## Questions & Answers

Legal/Request Descriptions & Location: 336 Woodward Road SE Albuquerque NM 87102

C-101

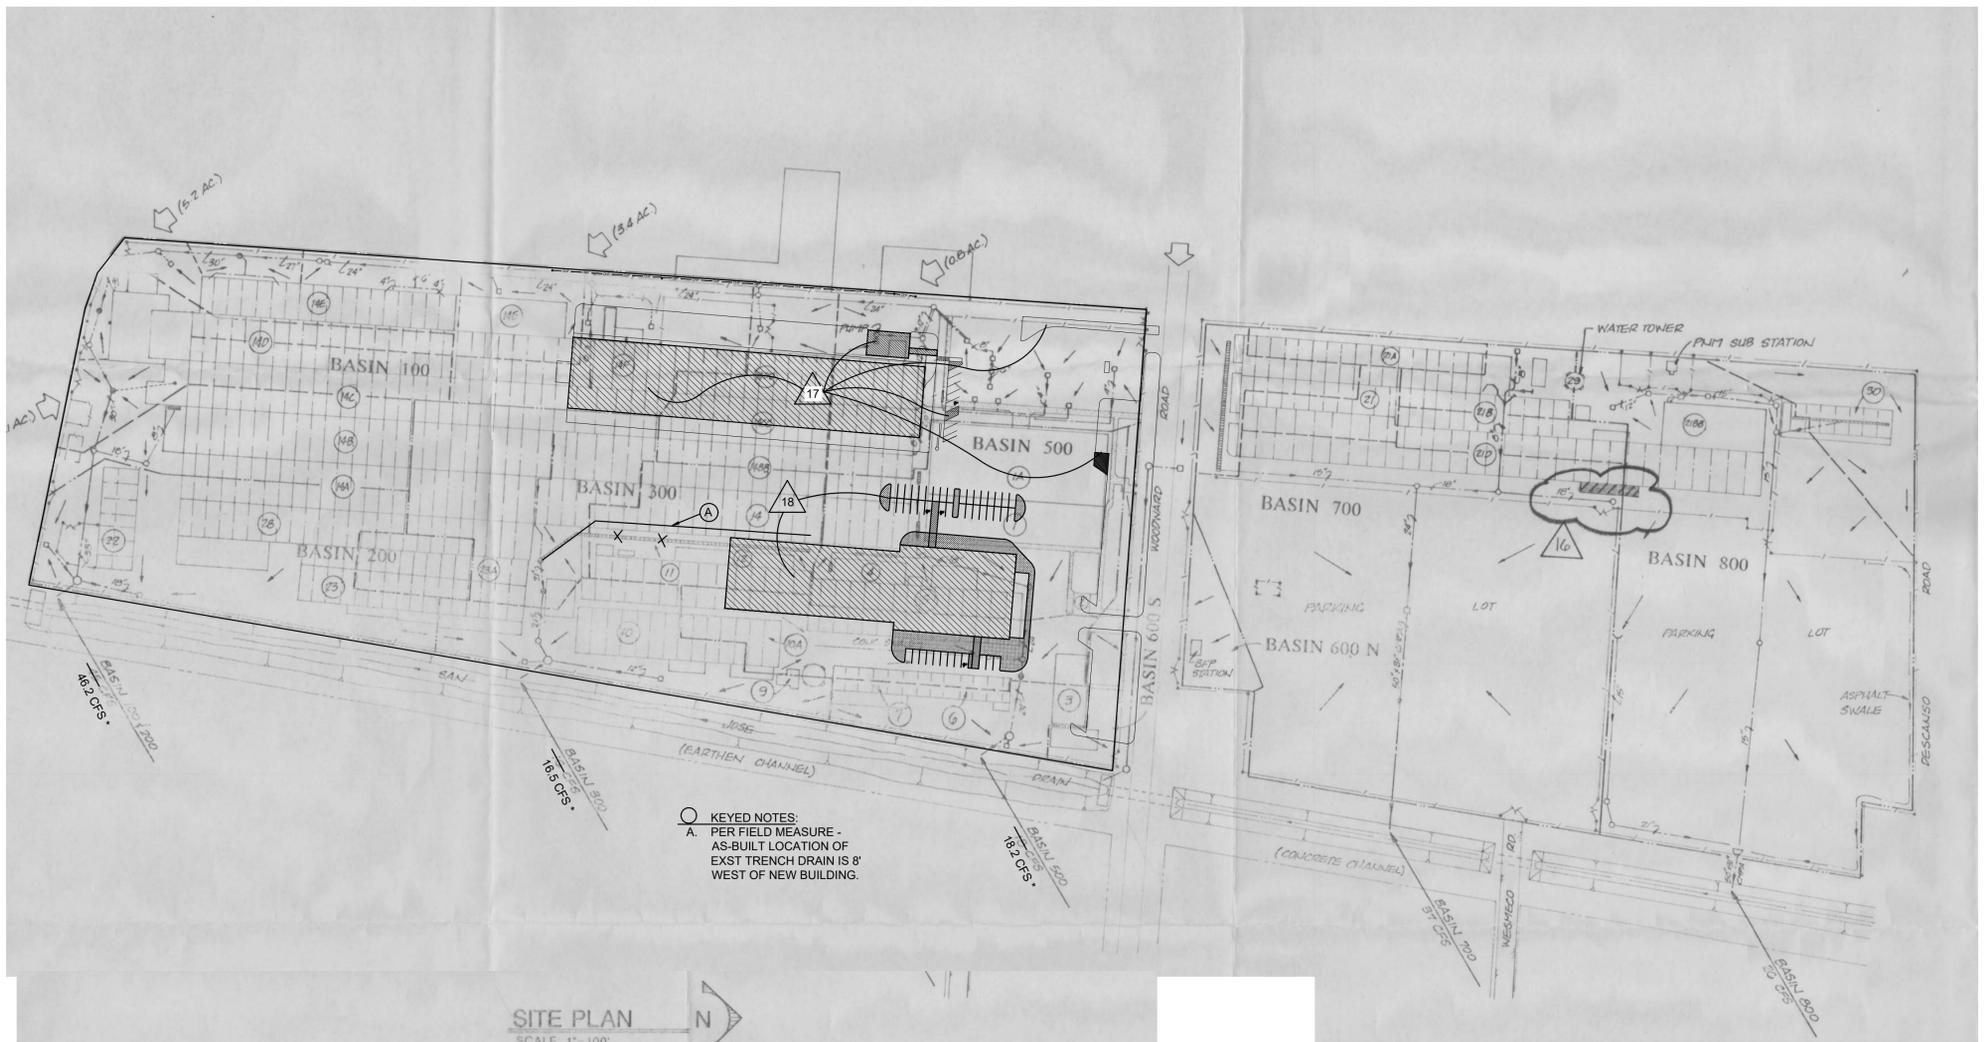
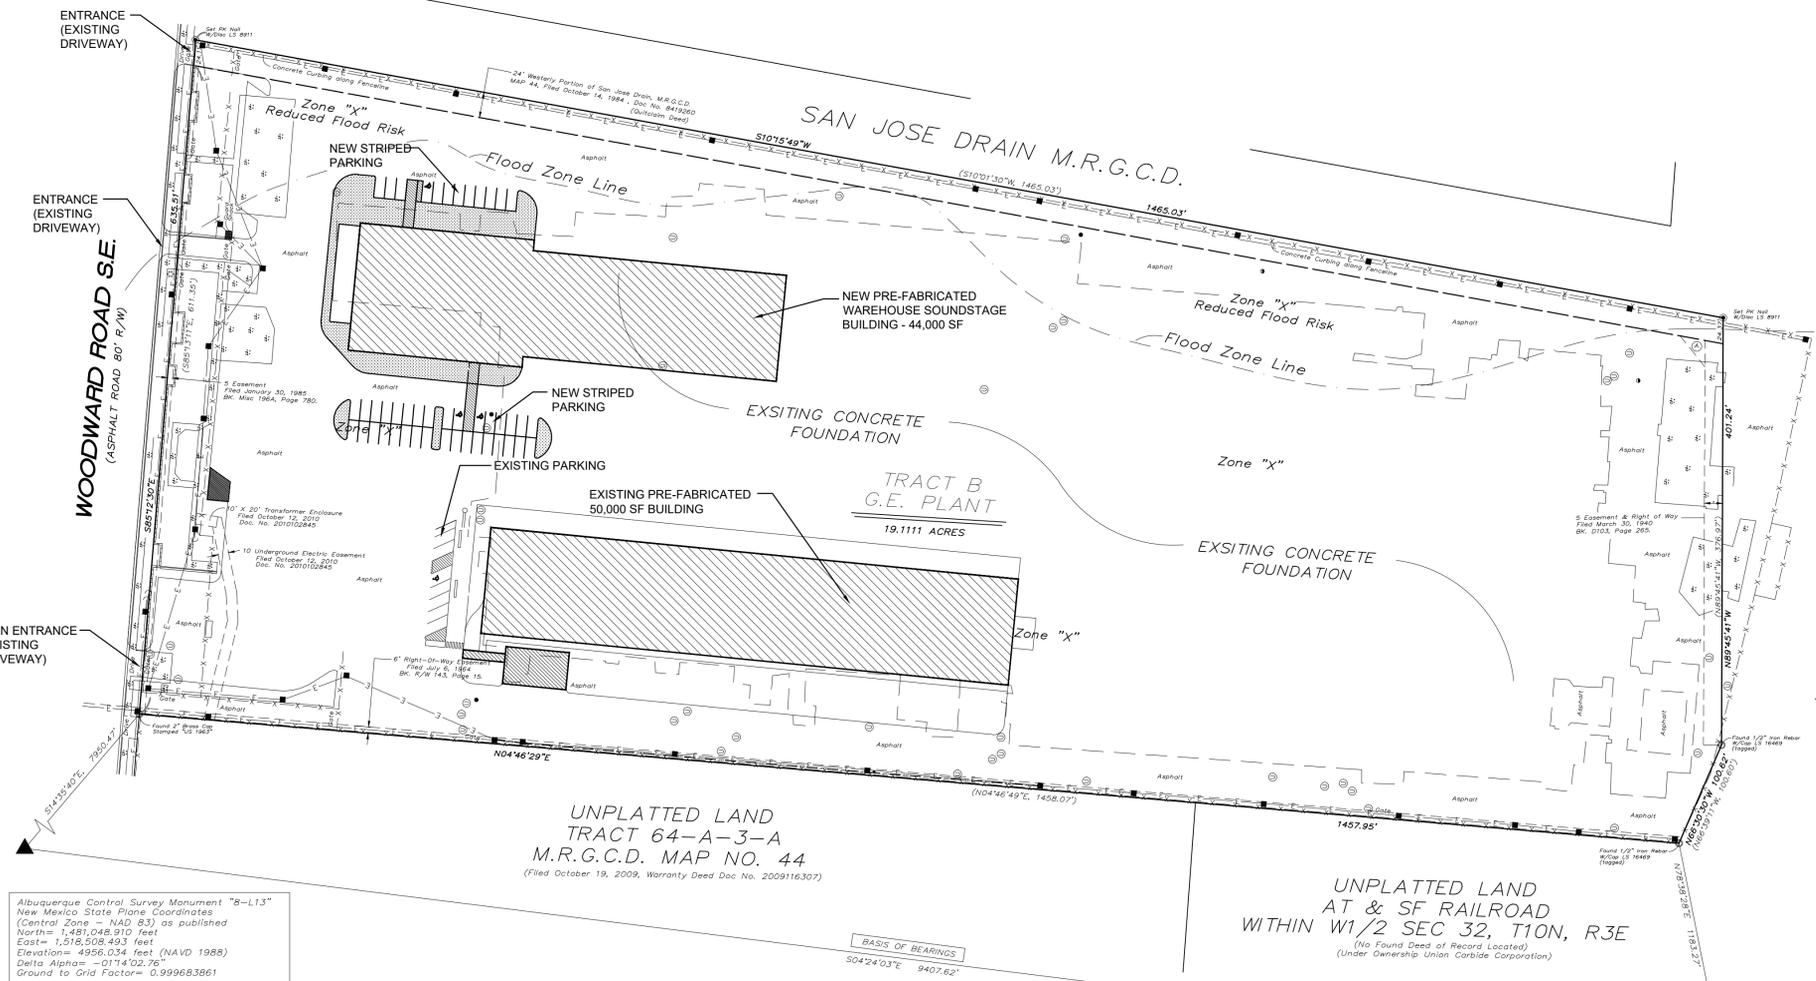
**-Approvals from Solid Waste, Transportation-TCL, Hydrology-G&D, Fire.**

**G&D:** We have an approved G&D plan already on the whole site. The previously approved plan covered the whole property (both the old site and the new). I've provided that signed plan. We've also submitted via ABQ Plan a G&D amendment that shows the proposed new building, but there are no other changes to that plan. Both are provided.
